Bristol City Council Development Management

Delegated Report and Decision

Application No: 21/00761/CPLB **Registered:** 15 February 2021

Application for a certificate of lawfulness of works to a listed building for the installation of a new boiler.

**FIRST FLOOR**

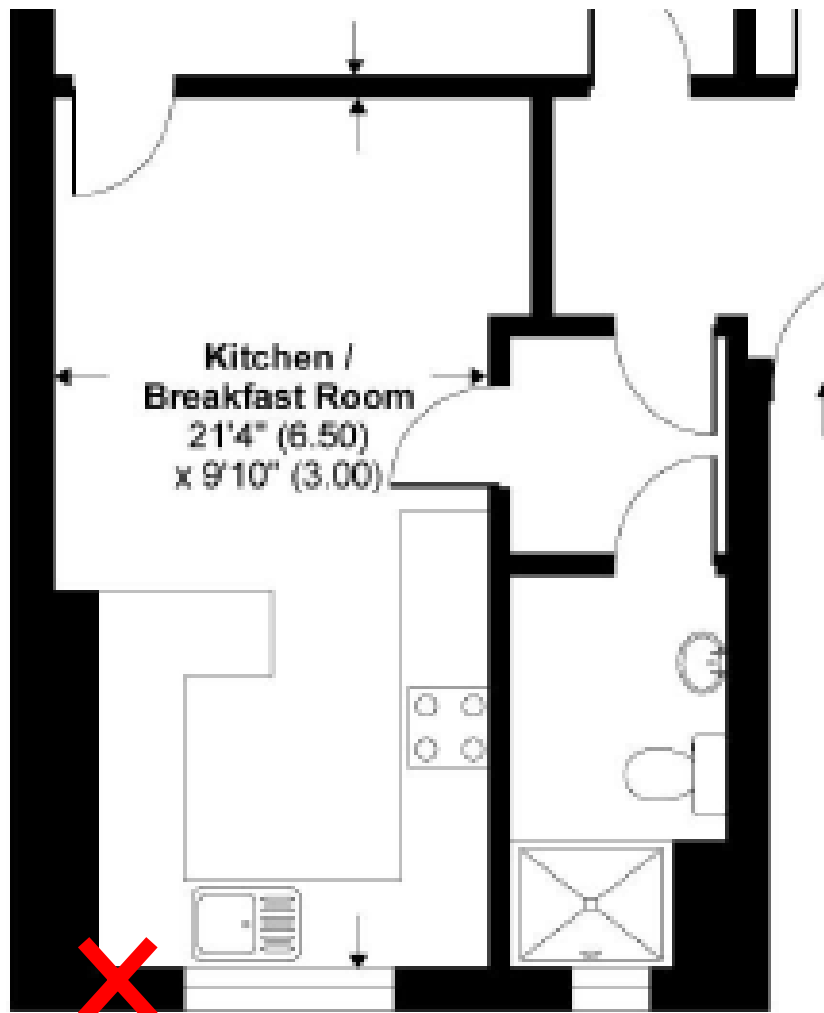
Formal consent is required as the work alters the fabric of the building by inserting a boiler flue to the rear which would be visible and introduces new material/s.

- 1 To assist with any future Listed Building Application - the below information is required:
 - (a) Manufacturer's details showing the size and appearance of the Boiler Flue.
 - (b) Internal photographs, including an internal marked photograph showing the proposed location for the boiler.
